KIRKLEES METROPOLITAN COUNCIL INVESTMENT & REGENERATION SERVICE

DELEGATED DECISION TO DETERMINE PLANNING APPLICATIONS

Reference No:	2025/62/93140/E
Site Address:	Kami Healthcare Ltd, 8, Market Place, Birstall, Batley, WF17 9EL
Description:	Installation of replacement shop front and internal shutter (within a Conservation Area)
Recommending Officer:	Nicole Helliwell

Officer Report

PP-Front-Market place		
1:100@A3	Date	12/12/25

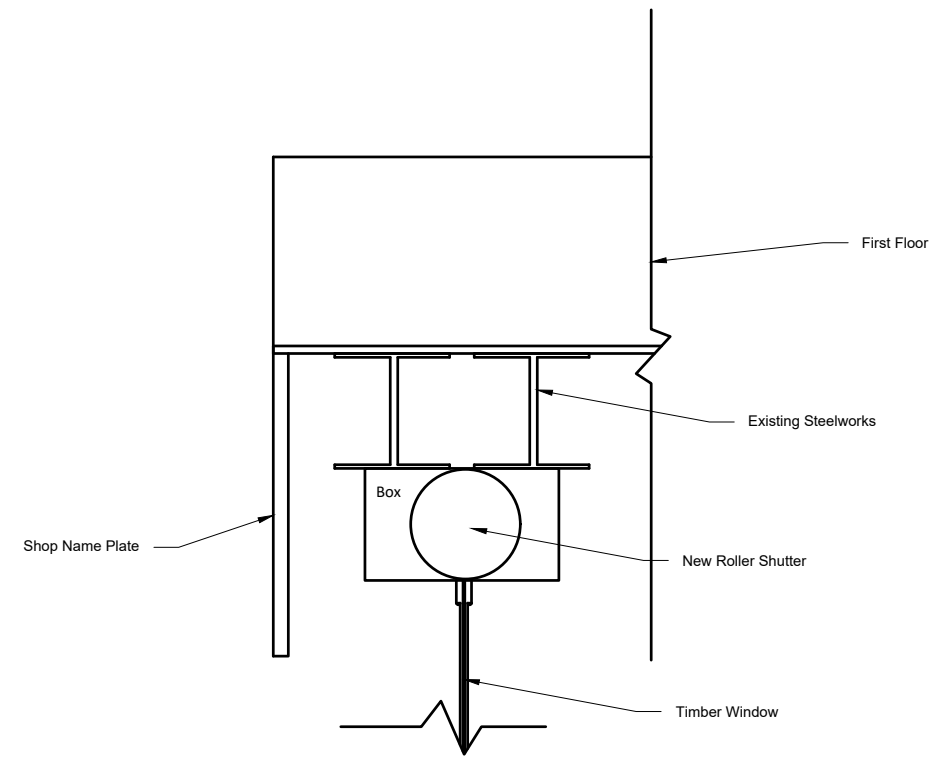
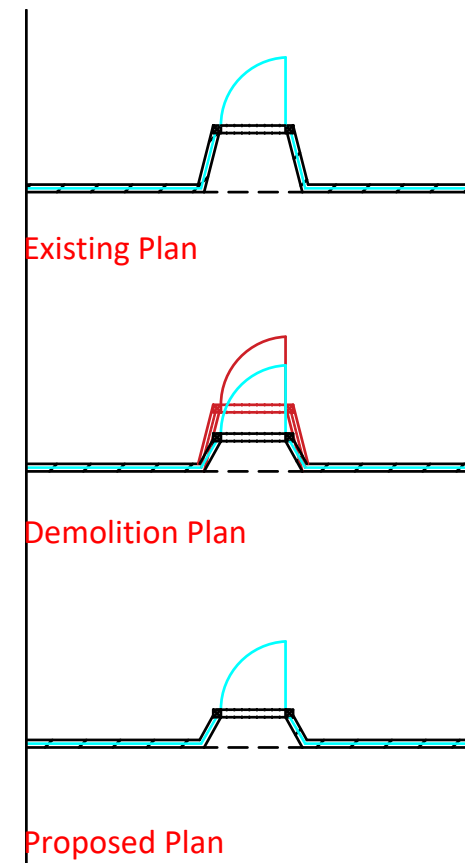
KC Conservation and Design raised concerns regarding the design of the proposal given its siting within the Birstall Conservation area and its proximity to the adjacent Listed Buildings. A request was made to omit the external roller shutter and replace it with an internal shutter. Revised drawings were received which were considered acceptable with regard to heritage and visual amenity.

- The proposed replacement shopfront and roller shutter are inappropriate in design and appearance and would detract from the traditional and historic character of the building and the wider street scene.

- The proposal fails to respect the architectural integrity and heritage value of the existing building.
- The installation of an external roller shutter is particularly concerning.

- Solid or externally mounted shutters create a hostile and inactive frontage, harming the visual quality of the street and undermining the character of the Conservation Area. Such features are generally discouraged in historic areas due to their negative visual impact, especially outside trading hours.

PP-Front-Market place		
1:100@A3	Date	24/03/26

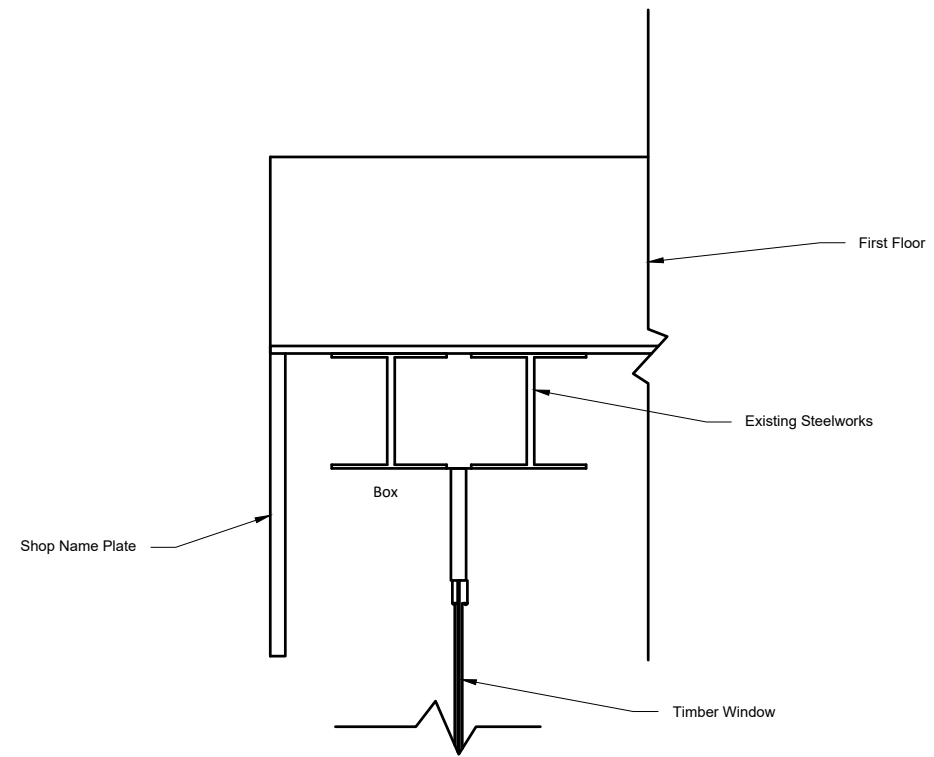
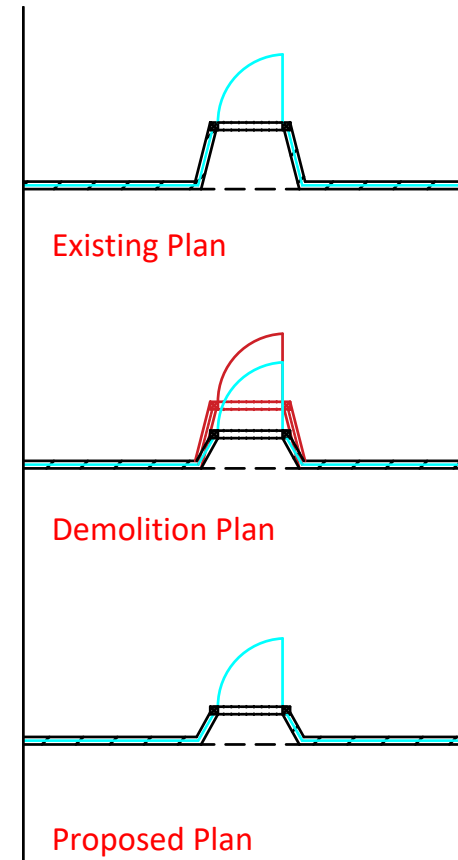
- The revised drawings do not show how the old stained-glass windows are going to be replaced. They are not there currently because they were smashed with a ladder when unauthorised work began. They are present in the next-door shop, with the shop sign covering them from the outside. They can be seen from the inside.

- The plans do not show any replacement.
- I am surprised therefore that KC Conservation and Design are stating that they have no problems with the drawings. I would ask that they visit the next door shop to see what they did look like at the former Chemist shop as they were an integral part of the heritage of the building.

- Given that context, it is difficult to accept that the current proposal preserves the historic shopfront as suggested in paragraph 5 of the heritage statement. The historic frontage no longer exists. This concern is reinforced by the fact that the submitted plans do not include the reinstallation or faithful reproduction of the original stained-glass windows, which were an important feature of the former pharmacy frontage. Without these elements, the proposal does not return the building to anything approaching its original or historic appearance.
